From: Maria Tomalova
Sent: Tuesday, September 28, 2021 3:09 PM
To: Ellie White [REDACTED]
Subject: Stakers Farm, Y/107/21/PL, Y/108/21/L

Stakers Farm North End Road Yapton BN18 0DU

Listed building consent for conversion of & alterations to existing barns to create 3 No. dwellings, erection of car barns & stores, a replacement pump house, demolition of barn, associated landscaping & parking (amendment to Y/106/19/L)

BARNS 1&2 PROPOSED SOUTH EAST ELEVATION
SHOWING SHUTTERS OPEN

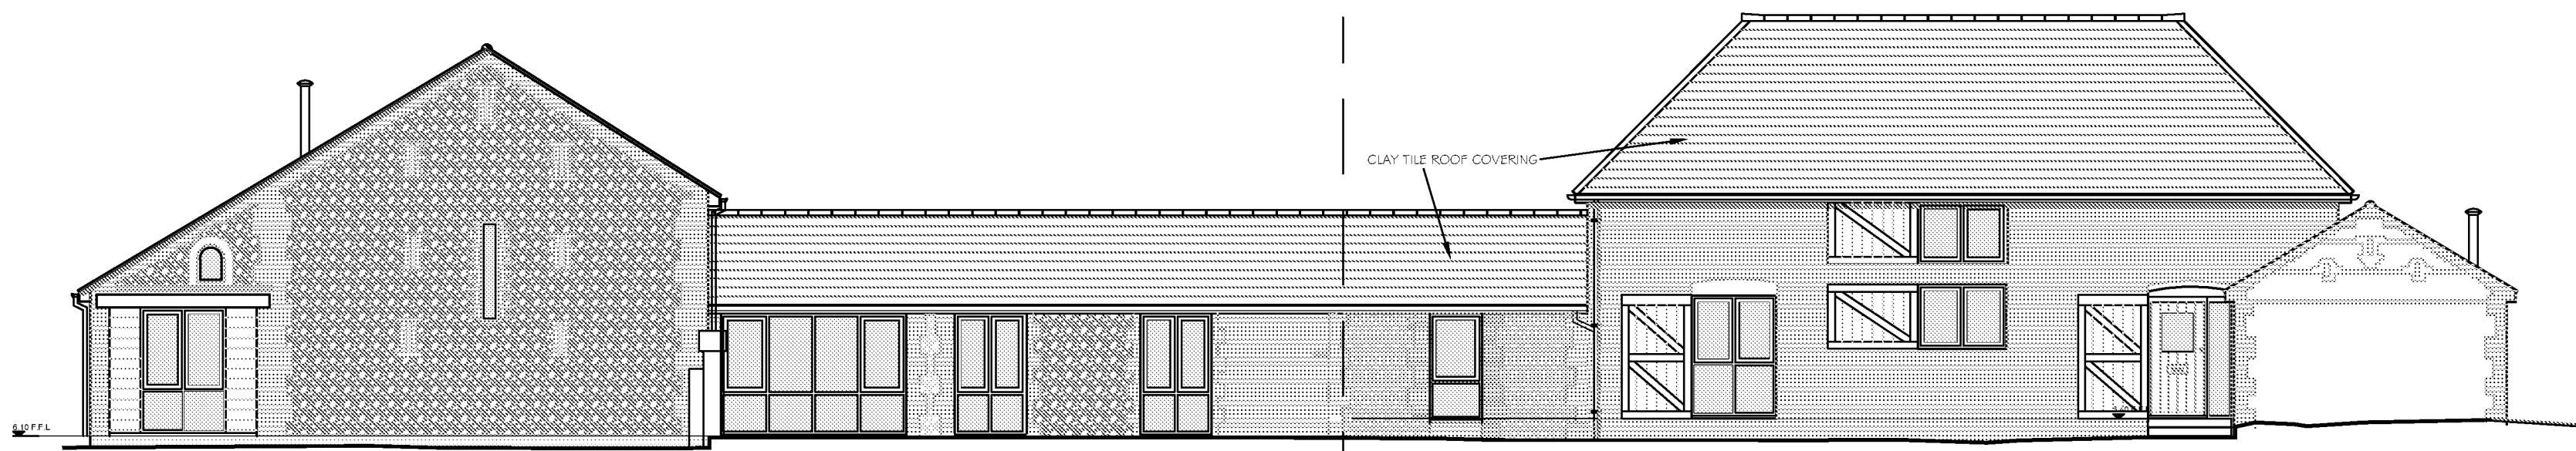
I am also concerned about the large window to be introduced to unit 2 on the South-East elevation, as well as the treatment of the existing opening for what will be bedroom three of the same unit. Further, it is not clear why the utility window of barn 2 is to be altered nor why a range of windows were chosen for the S.W courtyard elevation of barn one (when a more uniform appearance would be appropriate here). This requires clarification from the applicant, and it is suggested that more appropriate designs are prepared here.

BARN 1
PROPOSED SOUTH WEST COURTYARD ELEVATION
SHOWING SHUTTERS OPEN

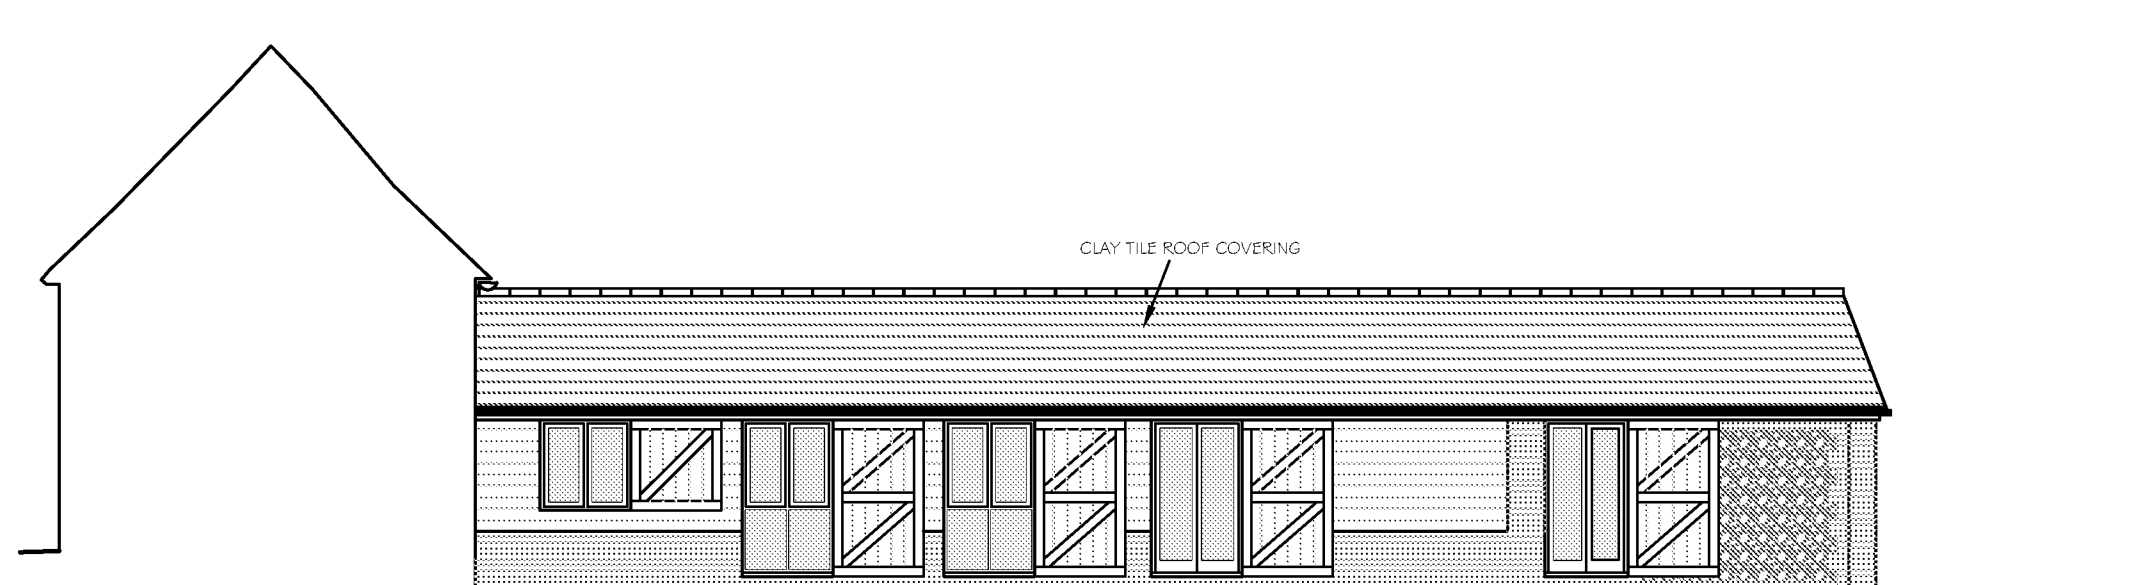
are not to be incorporated as part of the final scheme. This is disappointing, as they retain character as part of the building, and are reminders of previous use. Where doors remain, they can be retained and used as shutters; doors can be fixed open in order to ensure that enough light is available to the interior of the building. If in a poor state of repair, they can be repaired or replicated, or if missing, new ones can be made. This approach was used on the previous applications and it is not clear why it cannot be followed here as well.
